AENC-NG-CNS-REP-0208

Norwich to Tilbury

Document: 8.1 Errata List

Planning Inspectorate Reference: EN020027

Designed	S. Gkino	Date	21 Aug 25
Drawn	M. Pawaskar	Date	21 Aug 25
Checked	A. Fell	Date	21 Aug 25
Approved	K. Burrows	Date	21 Aug 25
Scale:	1:50,000	Datum:	AOD
Original Size:	A3	Grid:	OS
Suitability Code:	A2	Project Number:	10059280

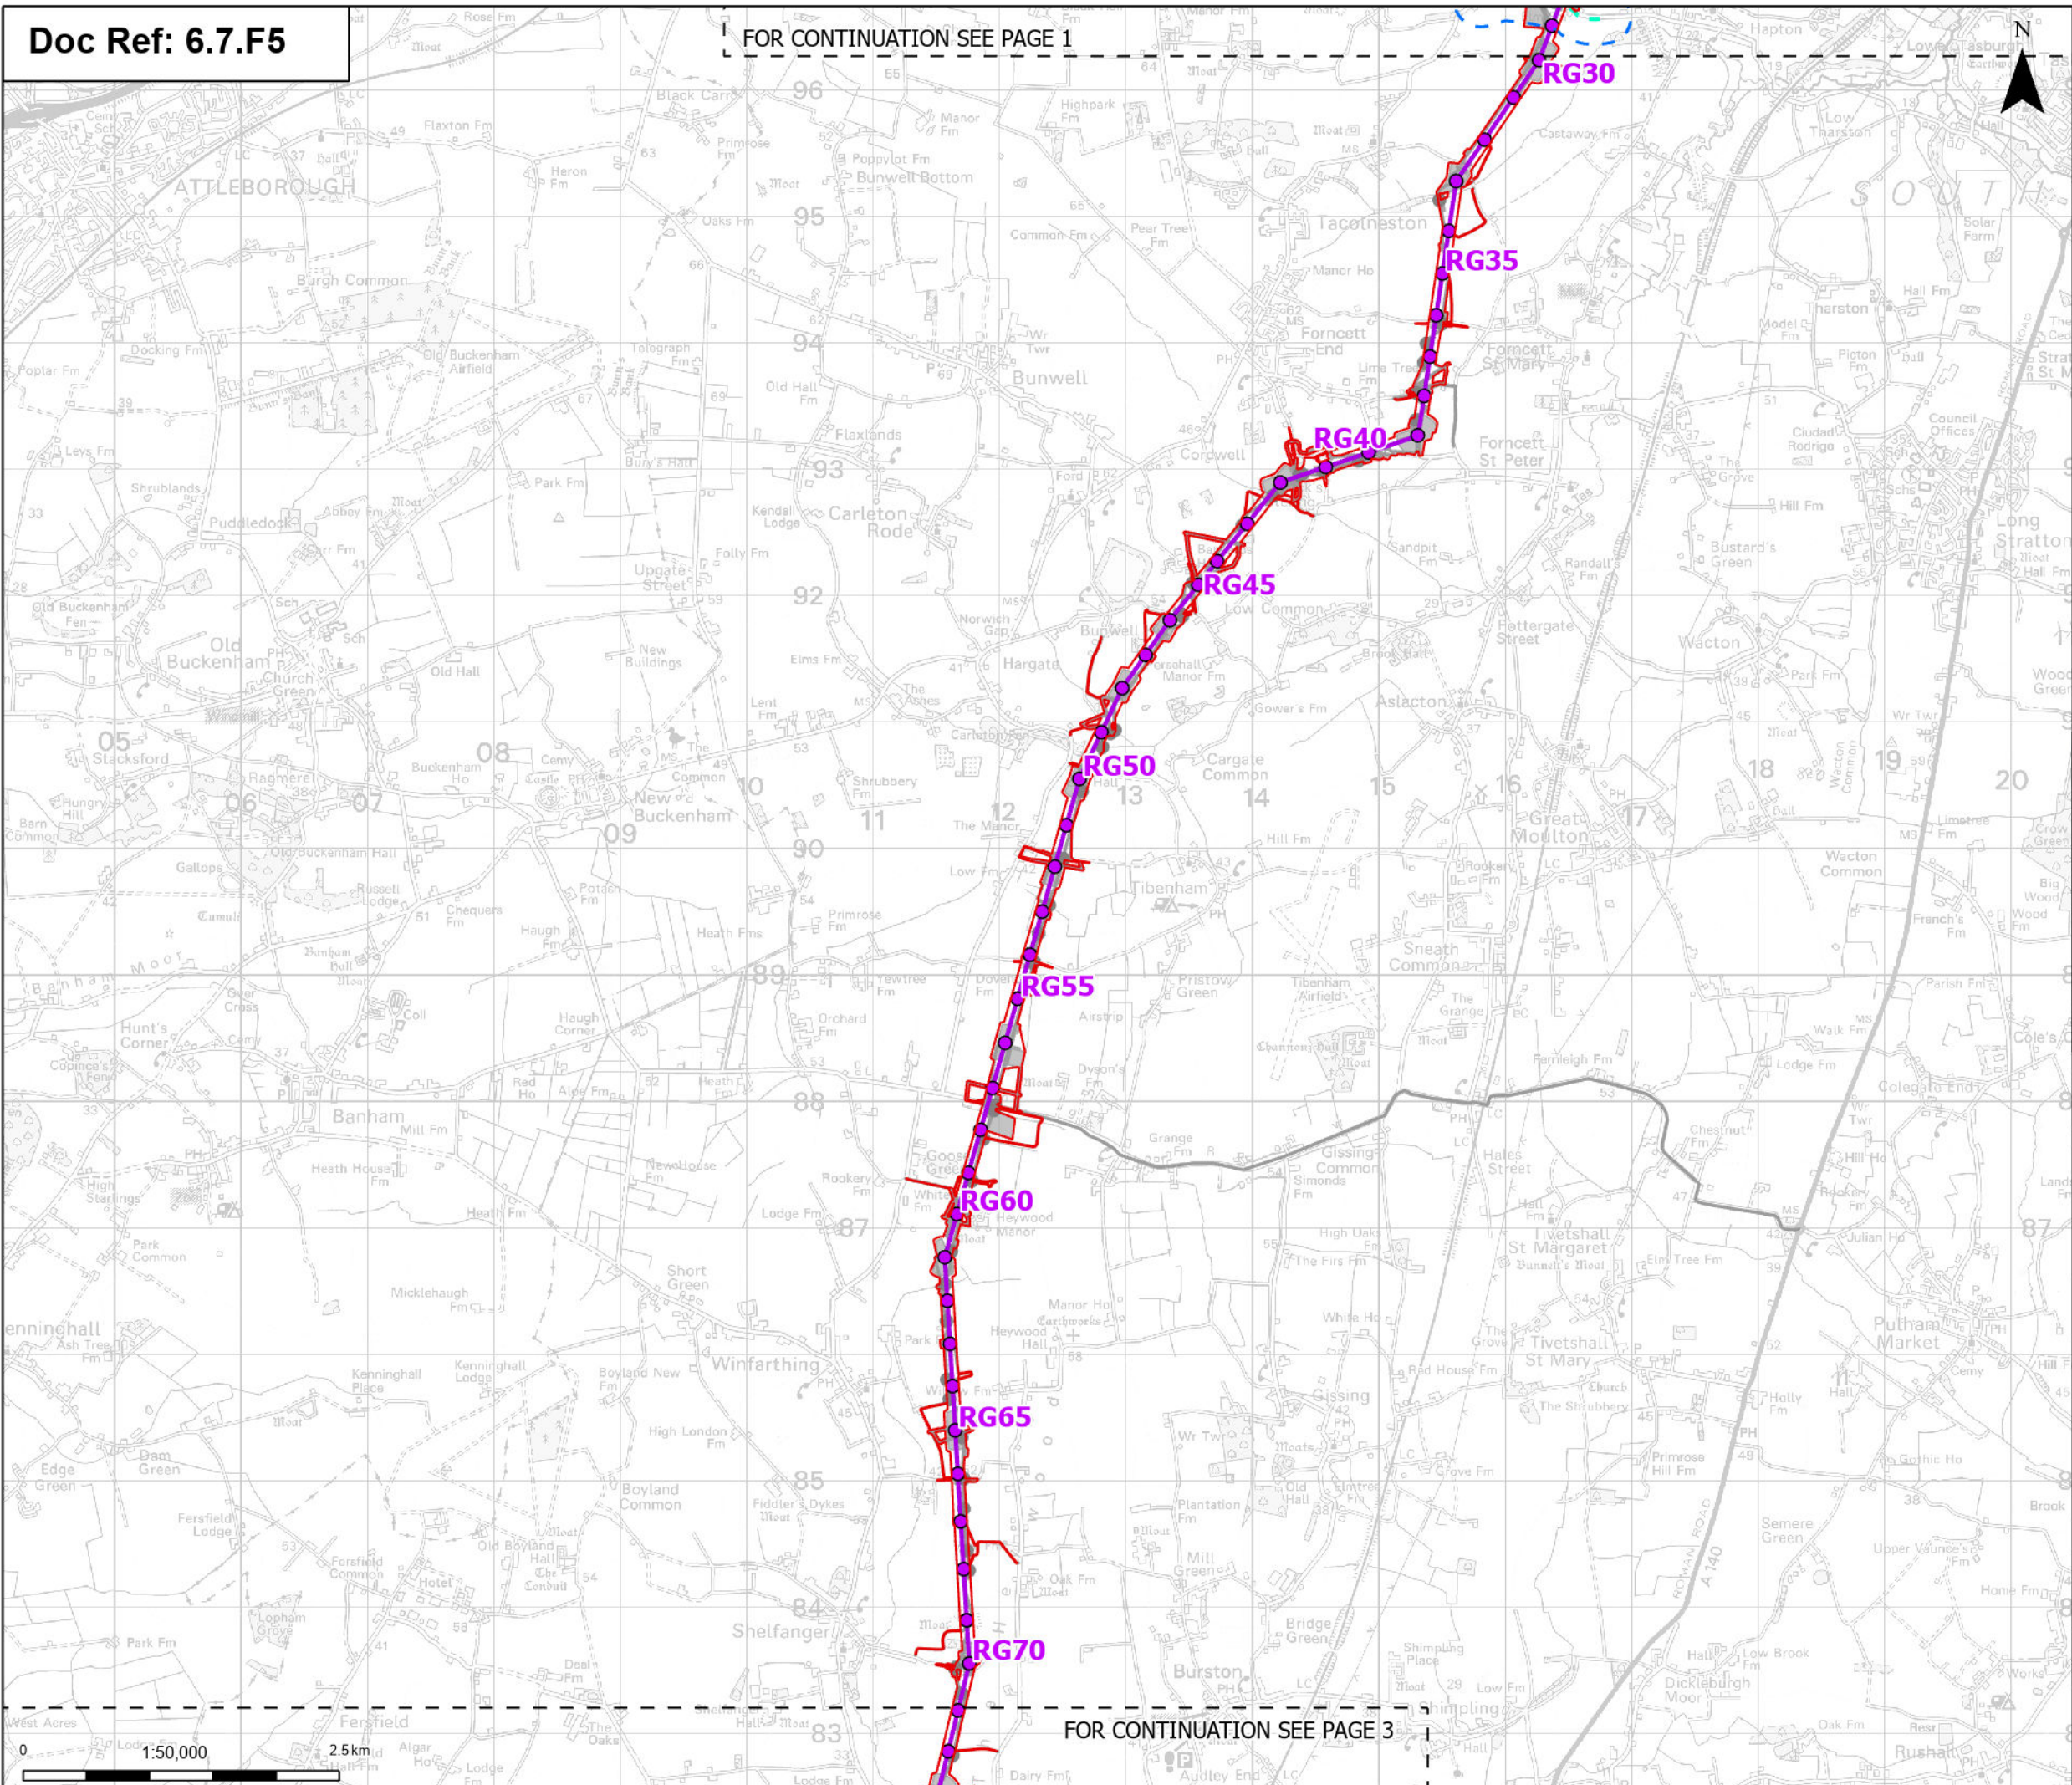
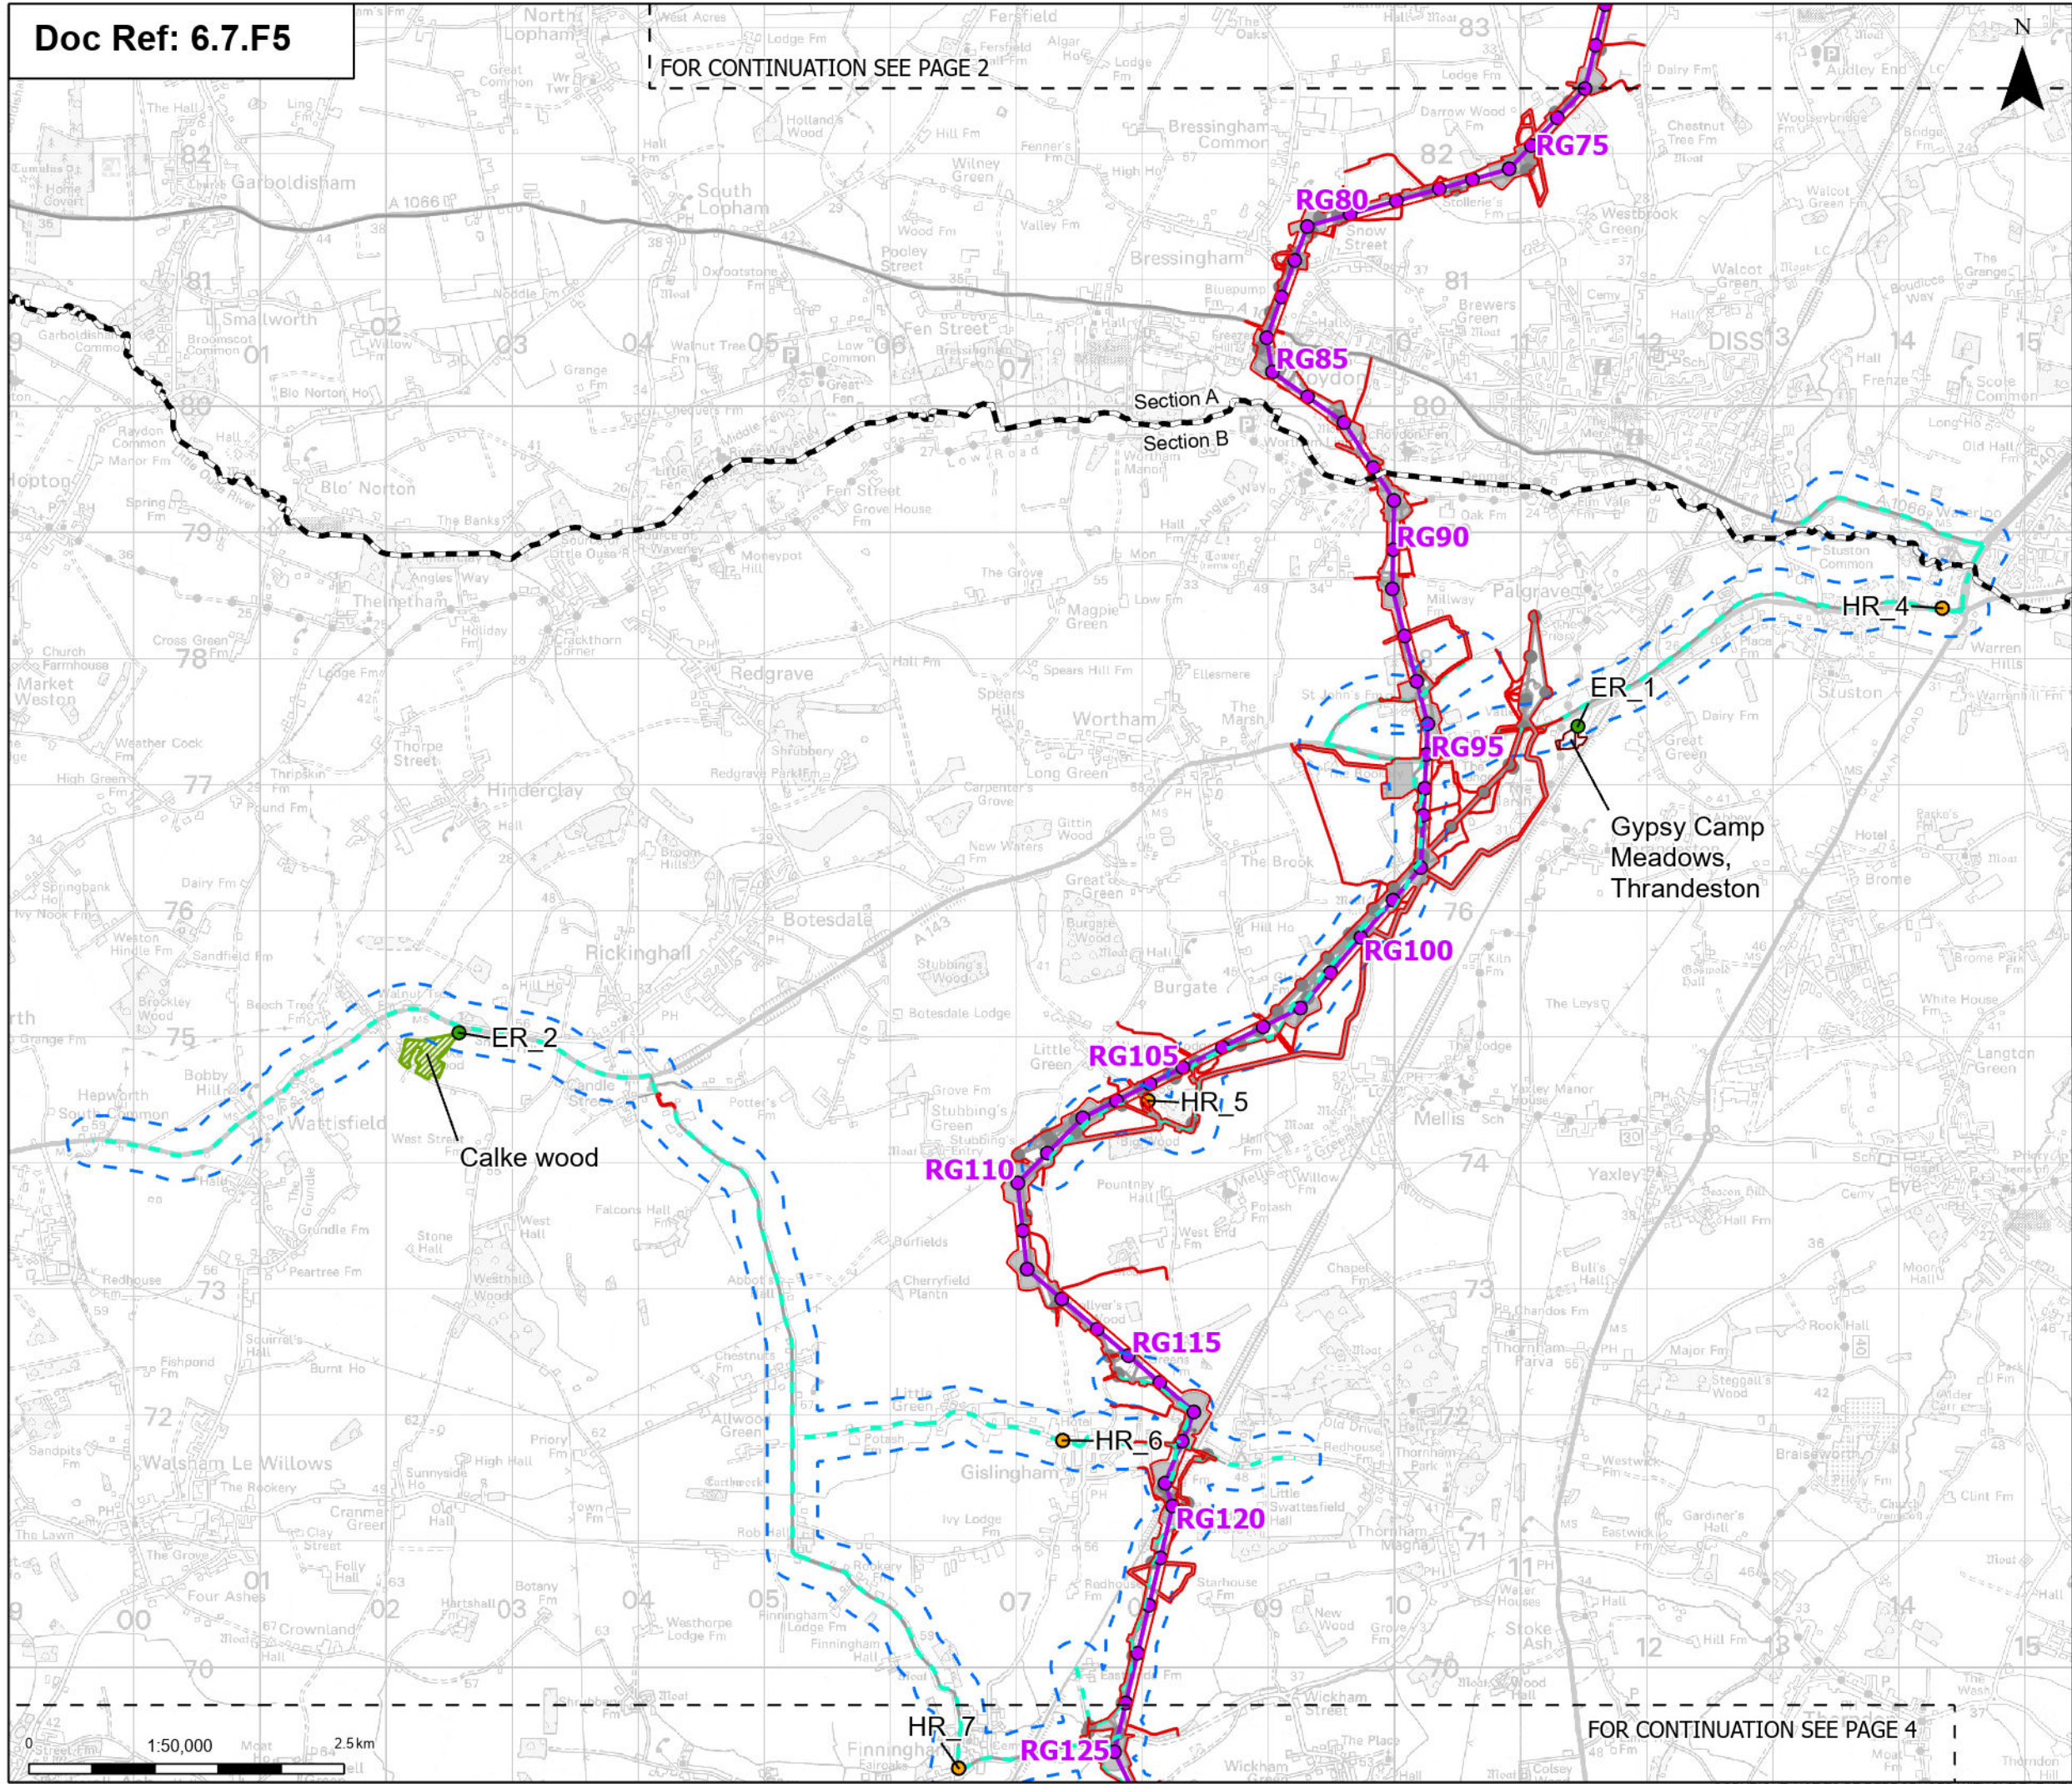
6.7.F5	Environmental Statement Figure 7.5: Air Quality – Affected Road Network	N/A	Duplicated dataset layer included within Figure.	Dataset ‘Project_Defined_AW_2’ is presented in error within the Figure. All data is included within the ‘Ecological receptors’ dataset. Therefore, the ‘Project_Defined_AW_2’ dataset should be ignored and ‘Ecological receptor’ dataset should be relied upon.
